MEETING NOTES

MEETING:	S.96 Modification 1 (SSD 5175 MOD1)		
PROJECT:	Eastern Creek Retail Centre (aka Eastern Creek Business Hub)		
TIME & DATE:	10:00am, Thursday 26 November 2015.		
LOCATION:	Blacktown City Council, 62 Flushcombe Road, Blacktown.		
ATTENDEES:	Judith Portelli	Blacktown City Council	JP
	Rebecca Gordon	Blacktown City Council	RG
	Perry Bezzina	Blacktown City Council	PB
	Dennis Bagnall	Blacktown City Council	DB
	Aneesh Singh	Blacktown City Council	AS
	Tony Merrilees	Blacktown City Council	TM
	Tim Colless	Western Sydney Parklands Trust	TC
	George Henien	Western Sydney Parklands Trust	GH
	Mark Wilson	Costin Roe Consulting	MW

SECTION 1:200
TYPICAL THRU OSD 1
DA4.0

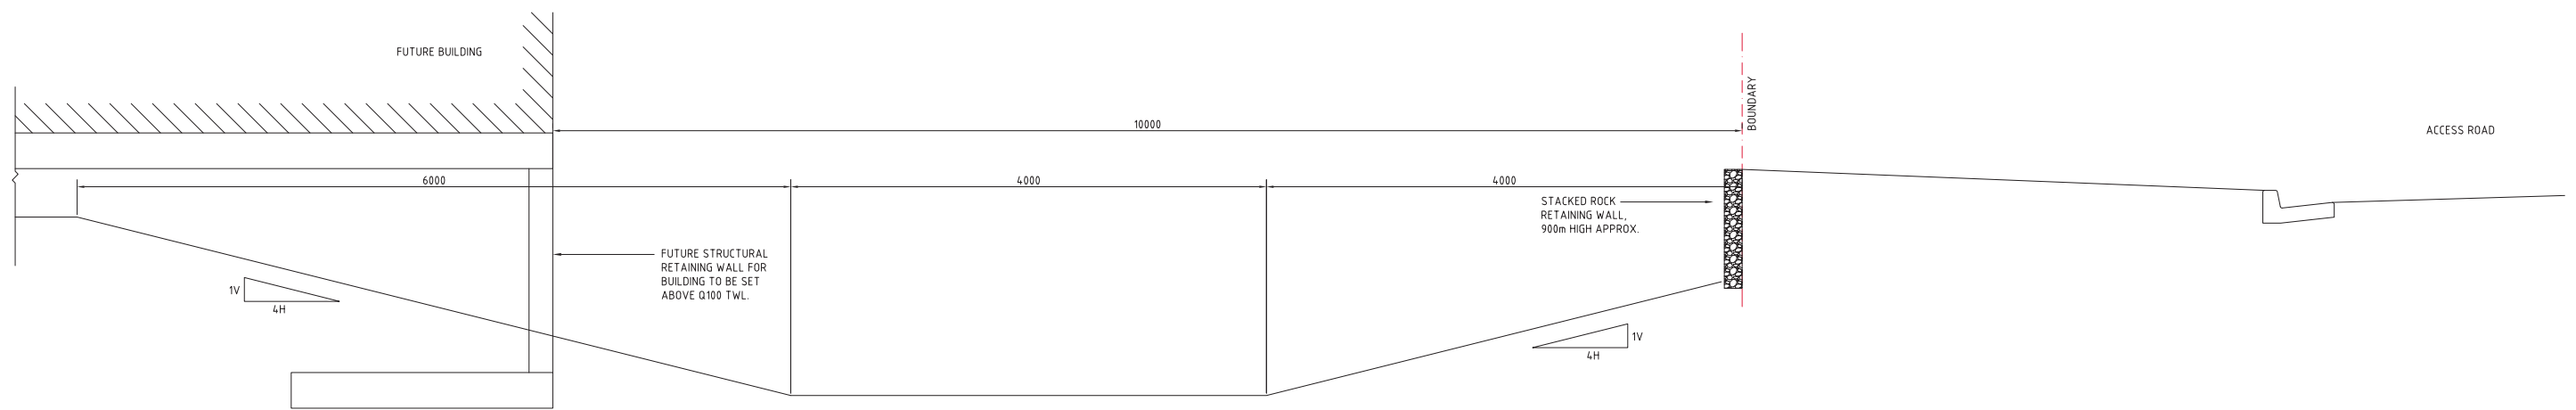
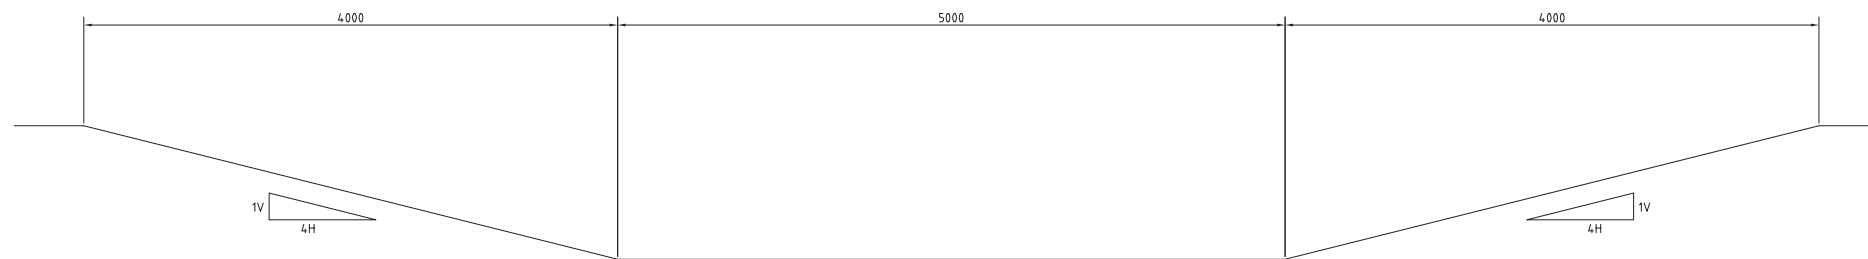
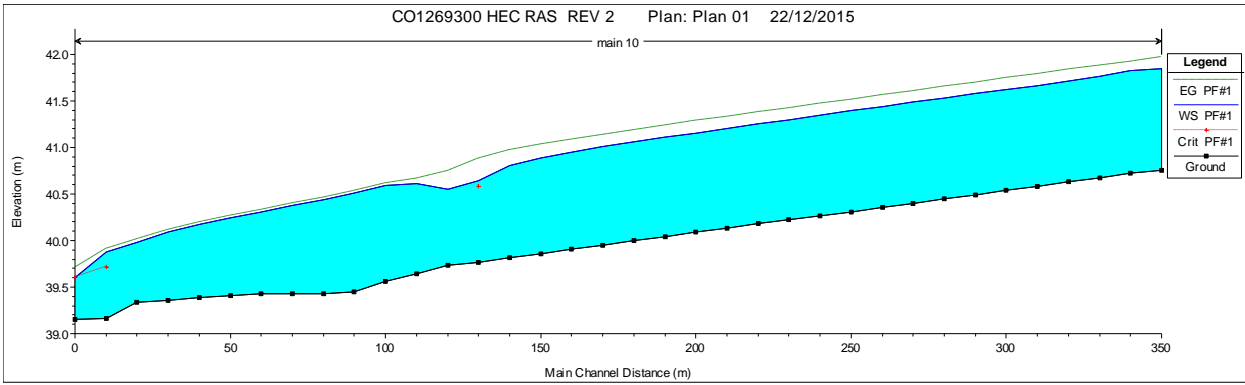
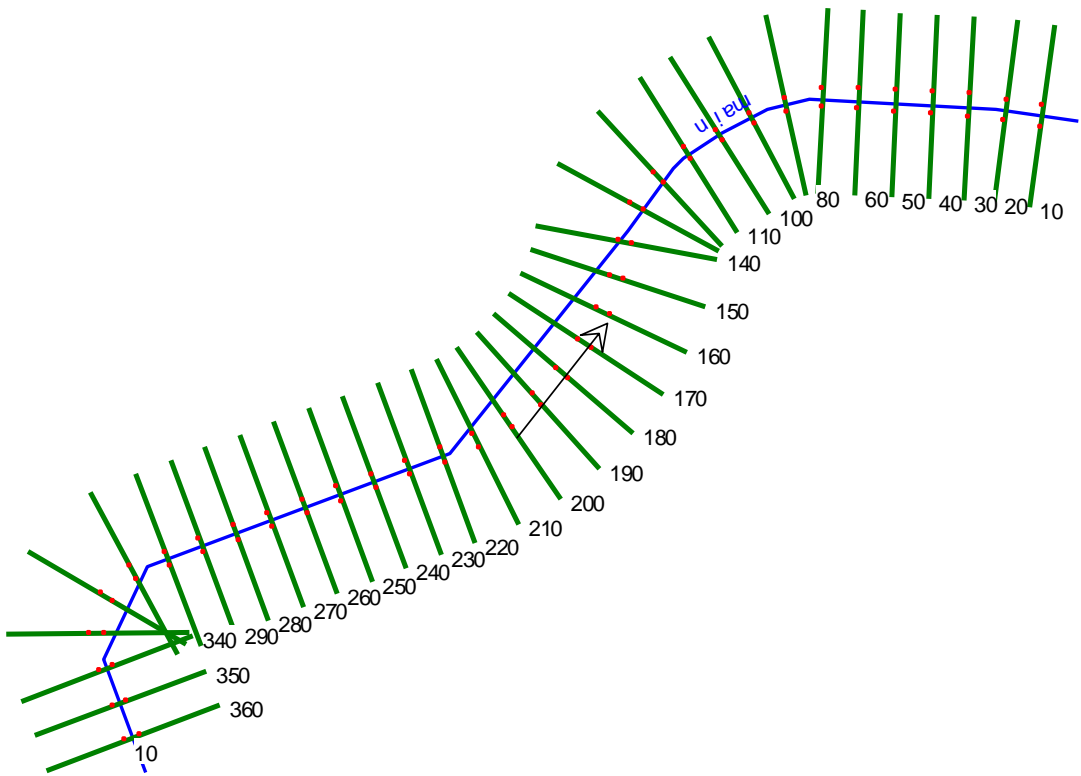
- JP raised concern that the path should not be at a level lower than the adjacent pads. MW advised that Drawing 35 includes a cross-section. Attendees reviewed the civil design which shows the pad to the east will be at a lower level however the lot to the west may be higher or equal. Council advised a preference for the pedestrian link to be on-grade with the higher pad. WSPT advised it would be given further consideration.

RETAINING WALL PLAN  
SCALE 1:1000

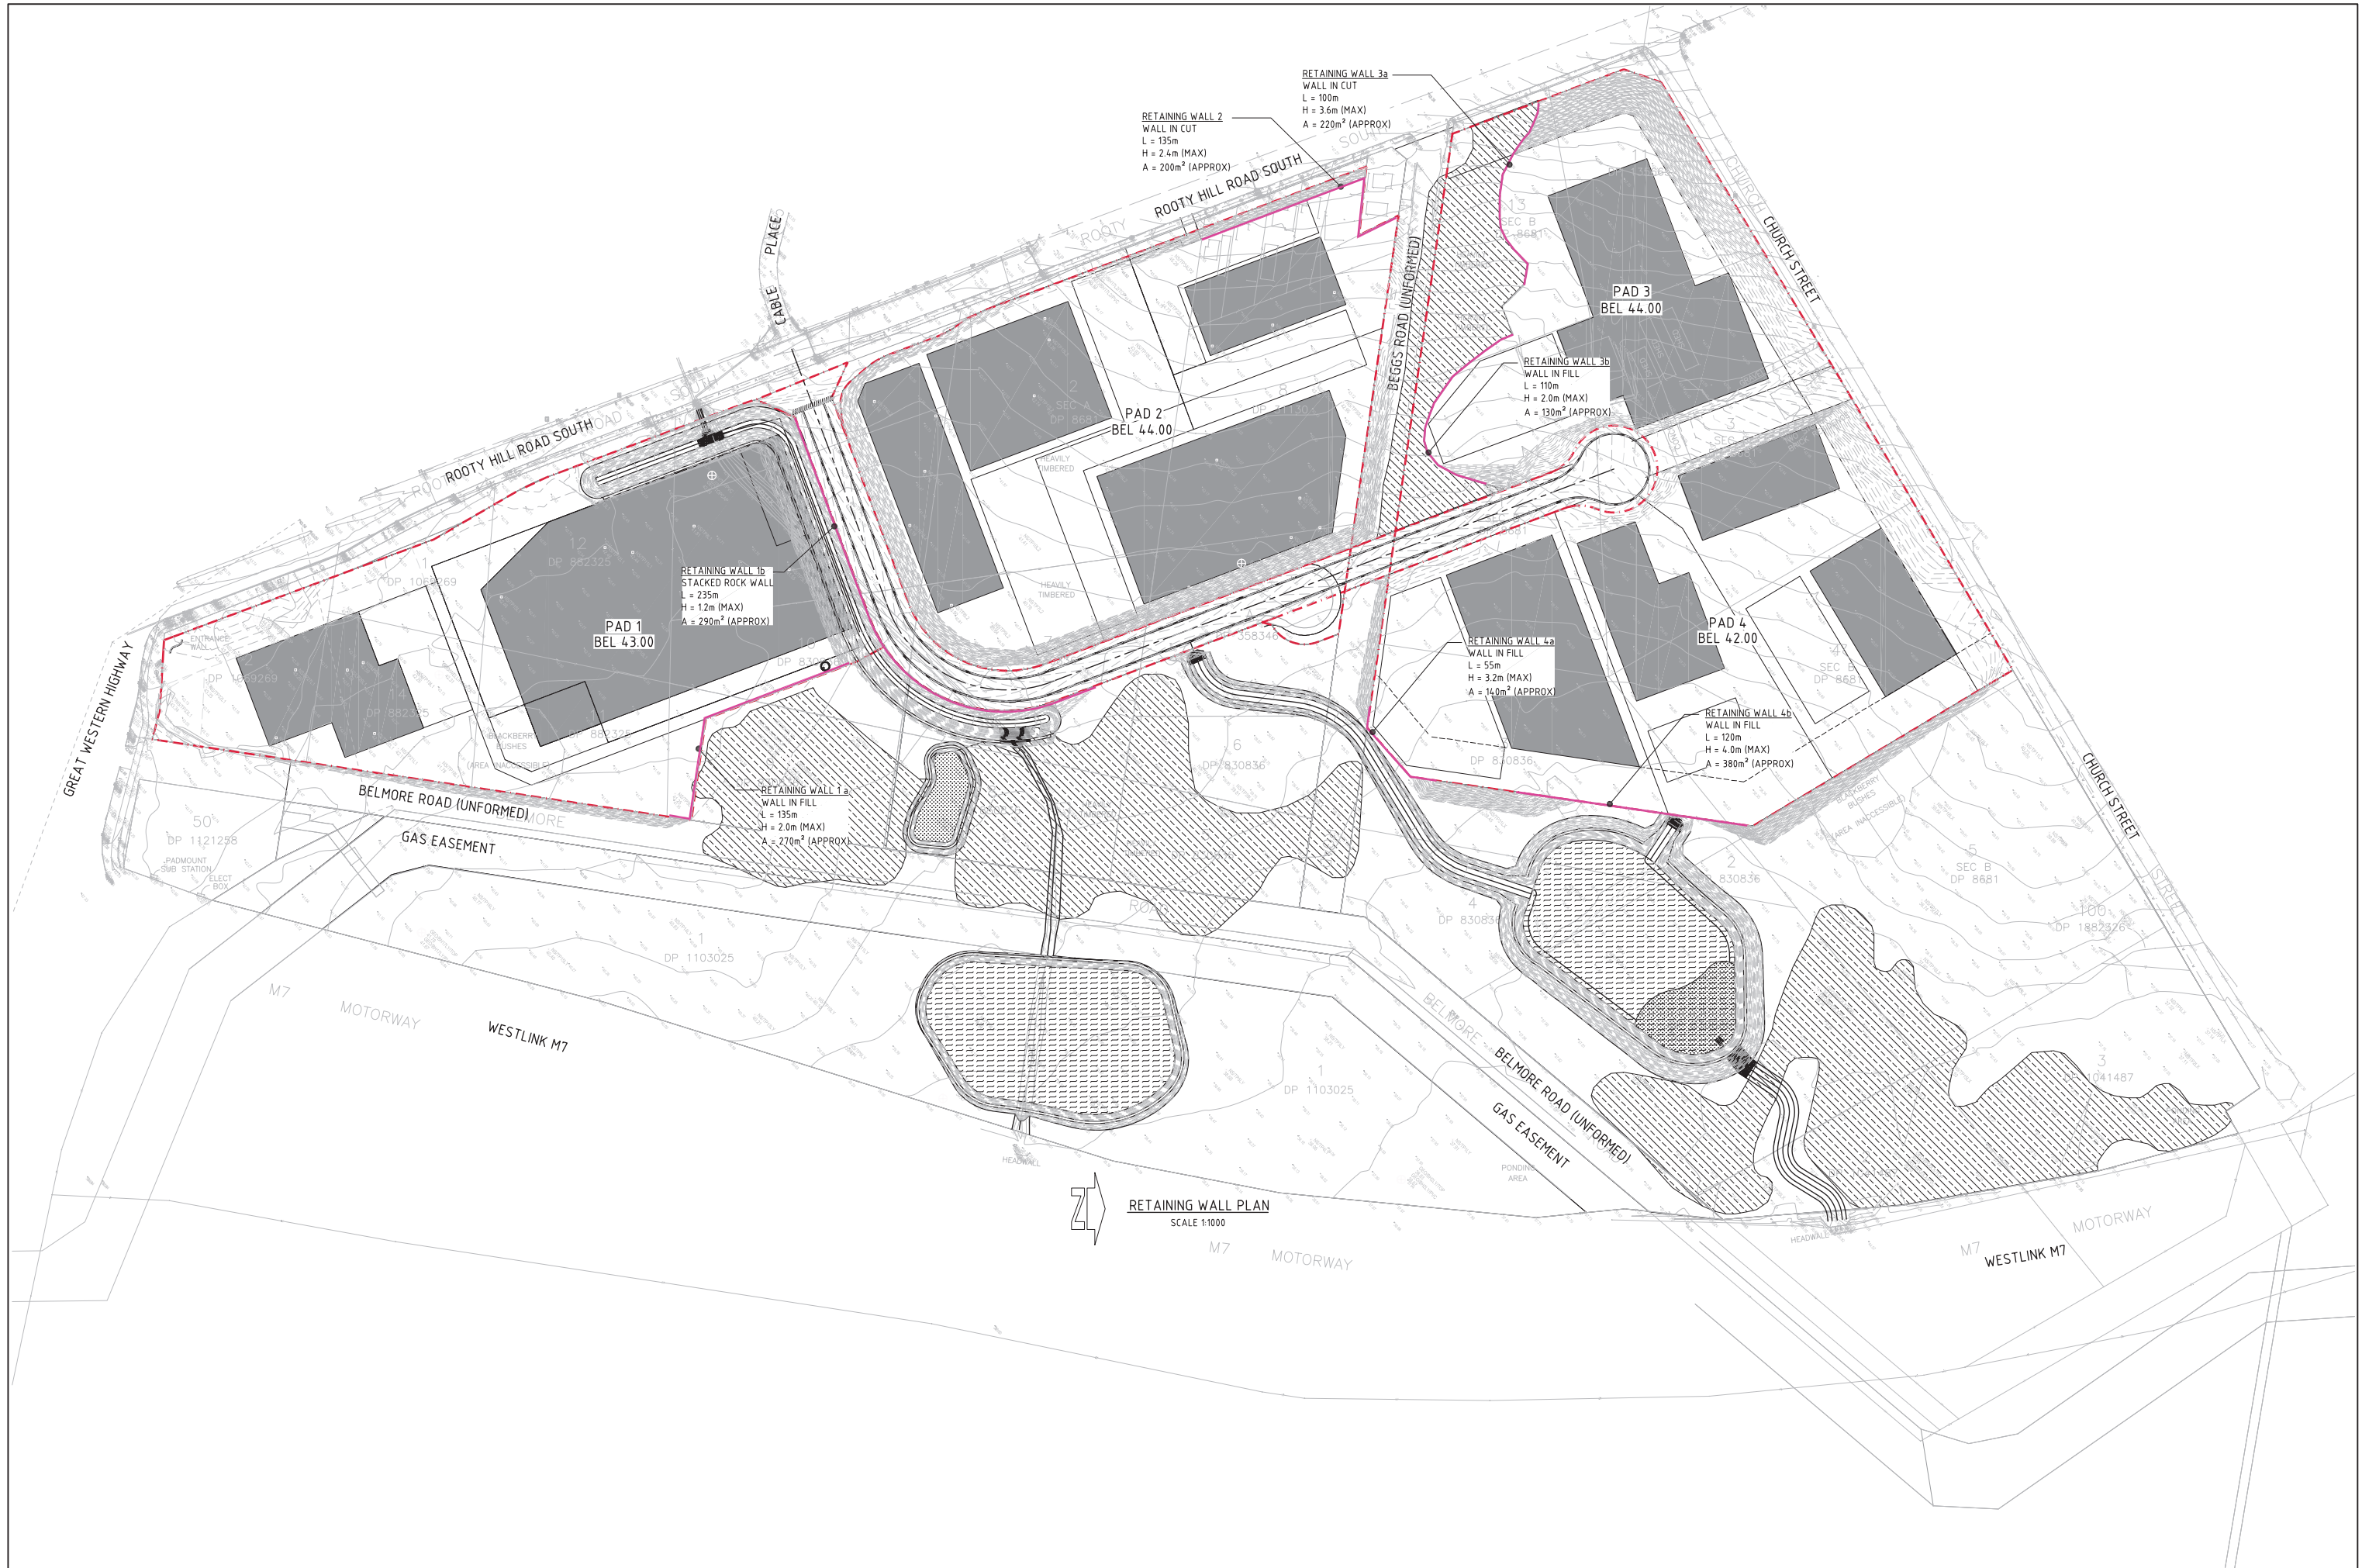
- MW advised that Council's submission notes retaining walls should be tiered after a height of 2m however 3m is stated in the Development Control Plan. Council accepts the height can be 3m if this is consistent with the Development Control Plan.
